Recommendation Report for Planning Permission for Works or Extension to a Dwelling

REF NO: FP/260/19/HH

LOCATION: 24 Outerwyke Road
Felpham
PO22 8HX

PROPOSAL: Erection of a first floor and entrance porch.

Drawing P01 November 2019 Scale 1:100 @ A3
Proposed Drawing - Ground Floor Plan & Elevations

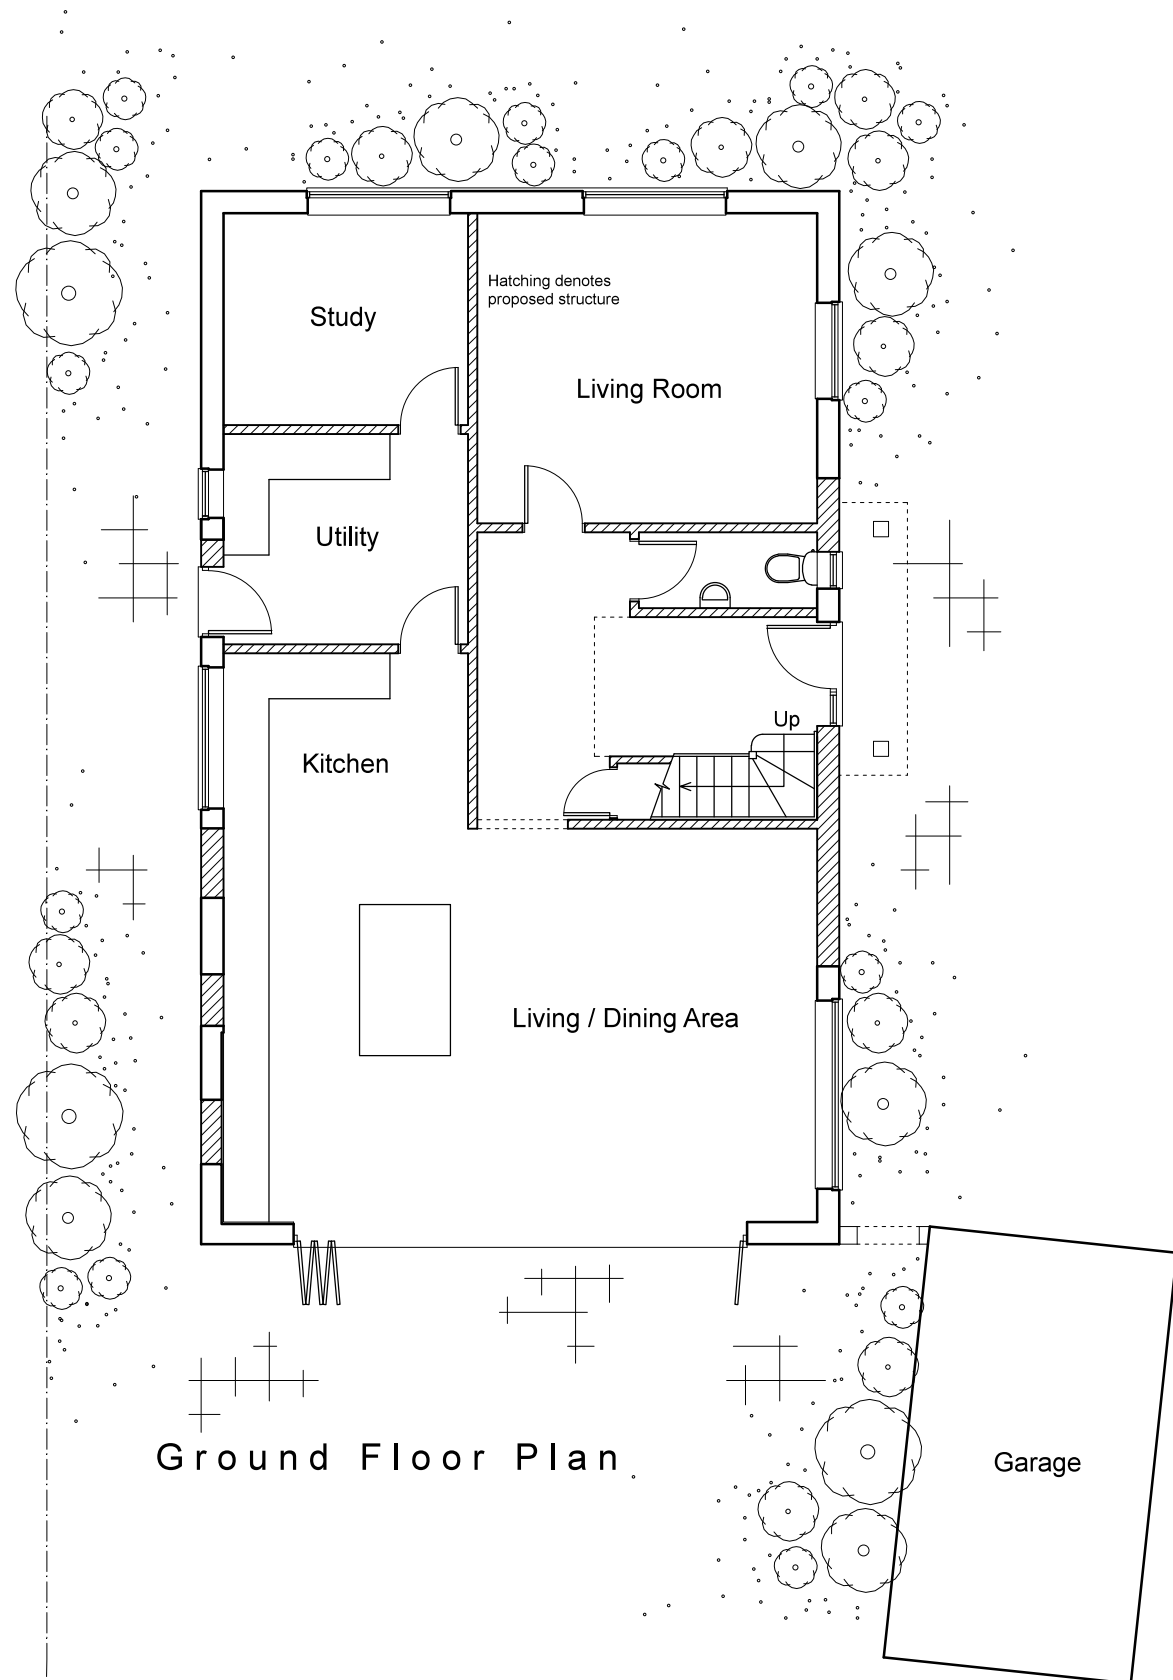
The proposal retains 7.5m to the front boundary. A covered porch area will also be constructed however will be sited to the eastern side of the dwelling where the existing access is. This is modest in size, extending 0.8m from the side elevation with a depth of 3.6m.

There are 3 windows proposed to the first floor east elevation of the host dwelling. These will face the dormer windows at No.26 and serve a landing and a bathroom. 2 first floor windows are also proposed to the west and serve bathrooms. It will be conditioned they remain obscured glazed to ensure no adverse overlooking.

Reason: To comply with Section 91 of the Town and Country Planning Act 1990 (as amended).
- 2 The development hereby approved shall be carried out in accordance with the following approved plans
 - Block Plan and Location Plan - P03
 - Proposed Plans - P02
 - Proposed Plans - P01
 - Email dated 26.2.20 confirming cladding colour.
Reason: For the avoidance of doubt and in the interests of amenity and the environment in accordance with policy D DM1 of the Arun Local Plan.
- 3 The first floor windows to the east and west elevation serving bathrooms and a landing shall at all times be glazed with obscured glass.

Drawing P02 November 2019 Scale 1:100 @ A3
Planning Drawing - First Floor & Roof Plan & Elevations

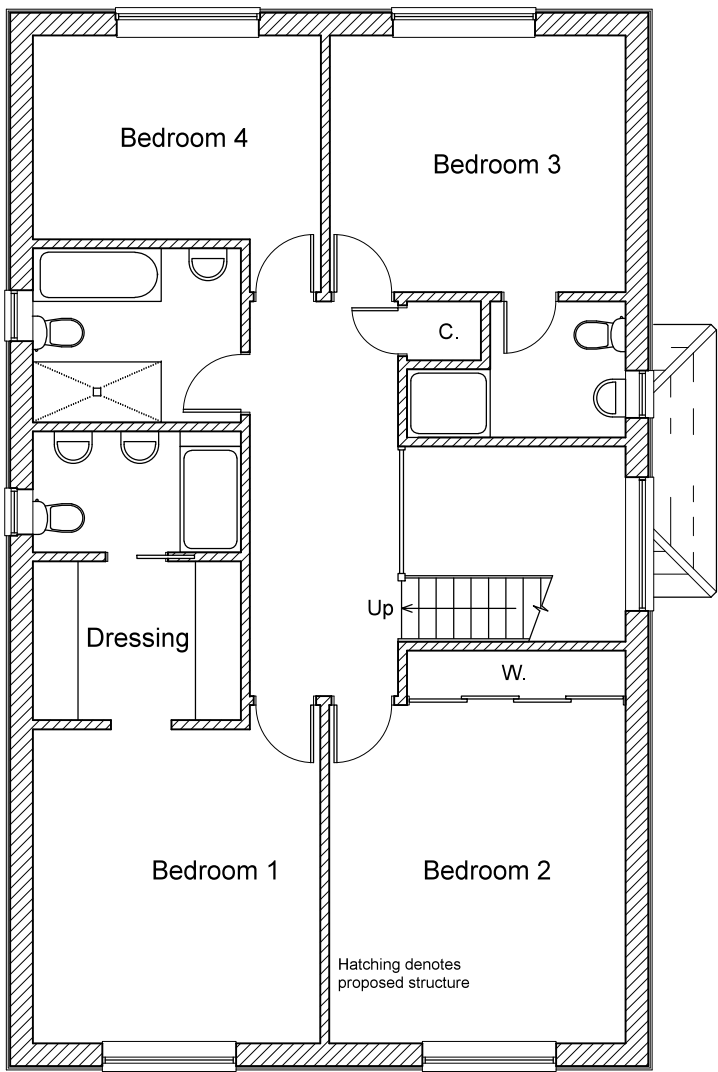
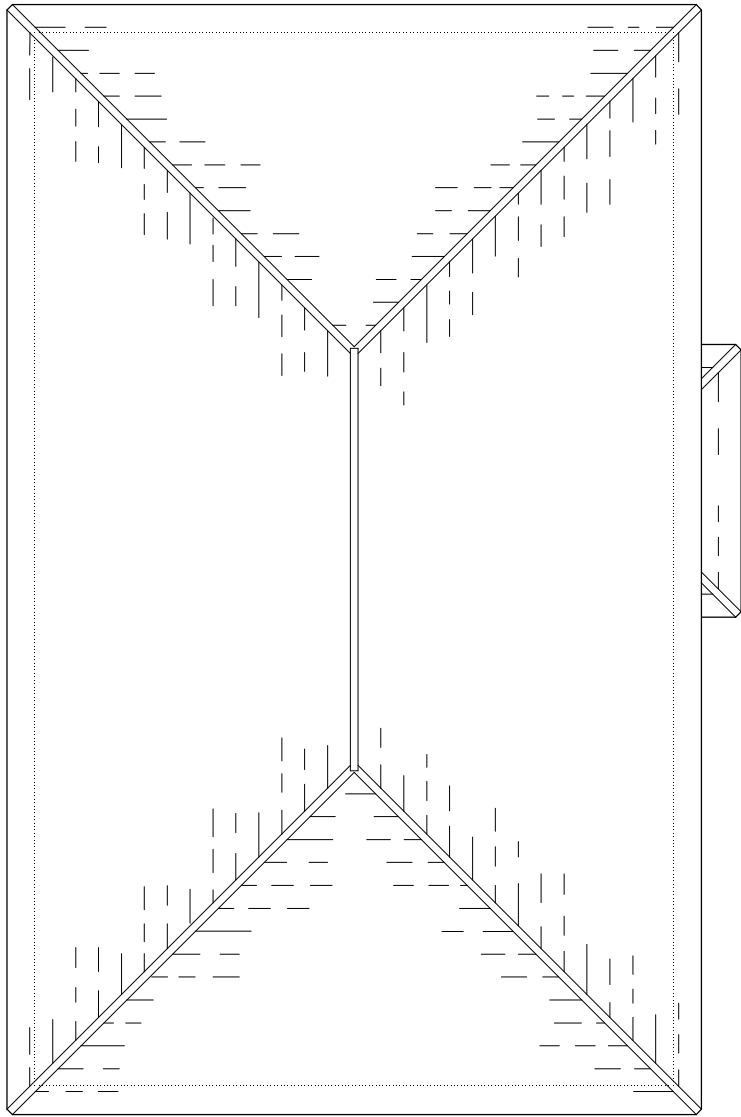
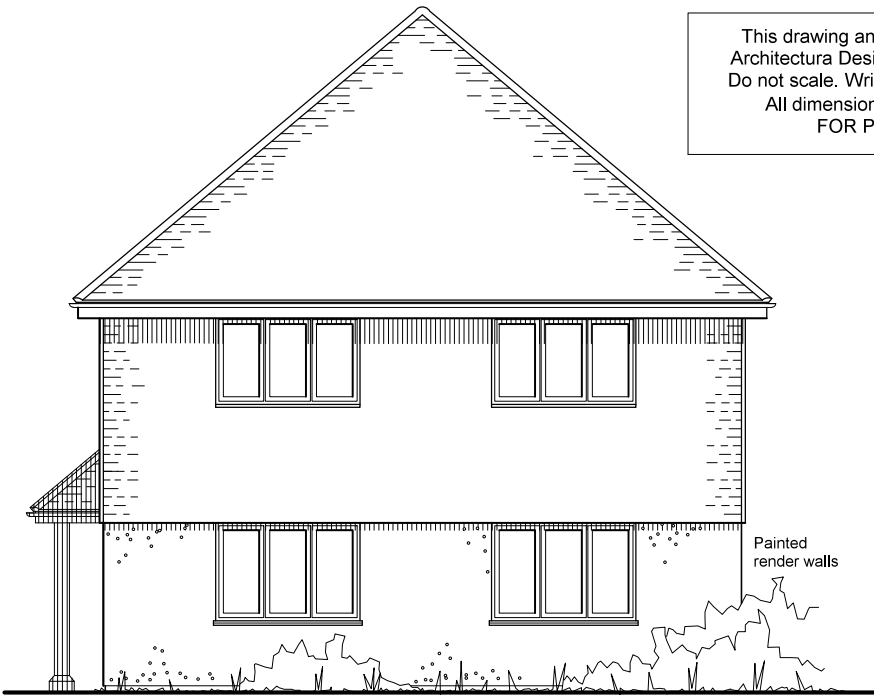
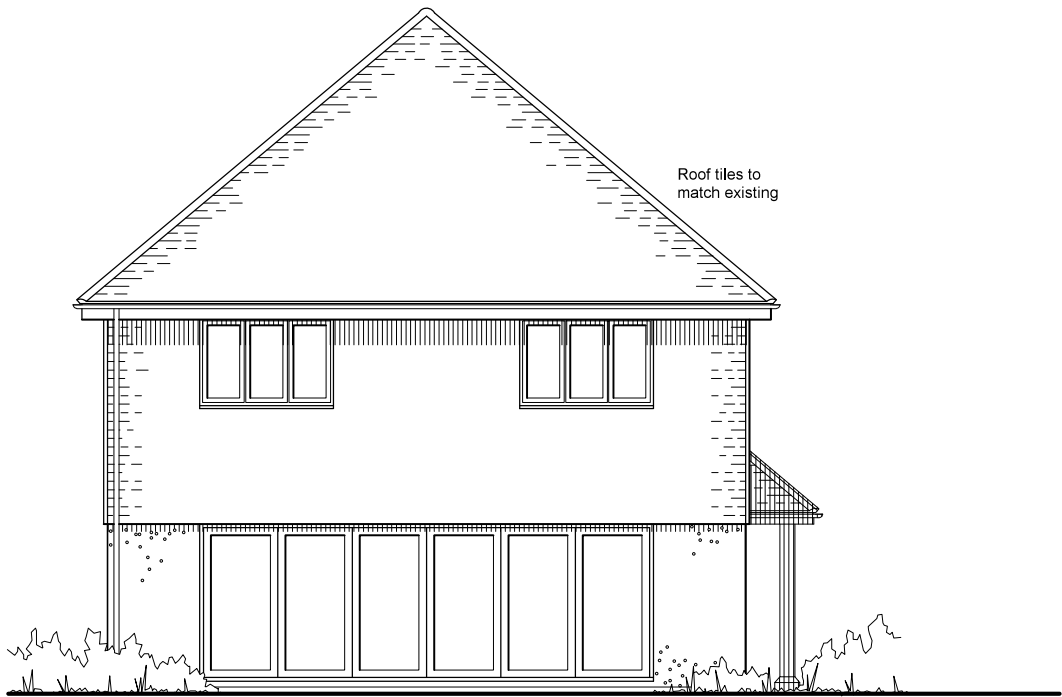
The proposal seeks cladding to the first floor. This will be dark grey in colour. Whilst there are limited examples of cladding in the area, the neighbouring property has grey cladding to the dormers and it is not considered that it would adversely impact the appearance of the dwelling within the street scene.

The site is currently occupied by a bungalow with a hipped roof to a height of 5.15m with eaves to 2.6m. With the addition of a first floor the height will increase to 9m with eaves to 5.4m.

There will also be additional windows to the rear elevation at first floor however views are of the rear garden and are not considered to result in harm upon neighbouring properties.
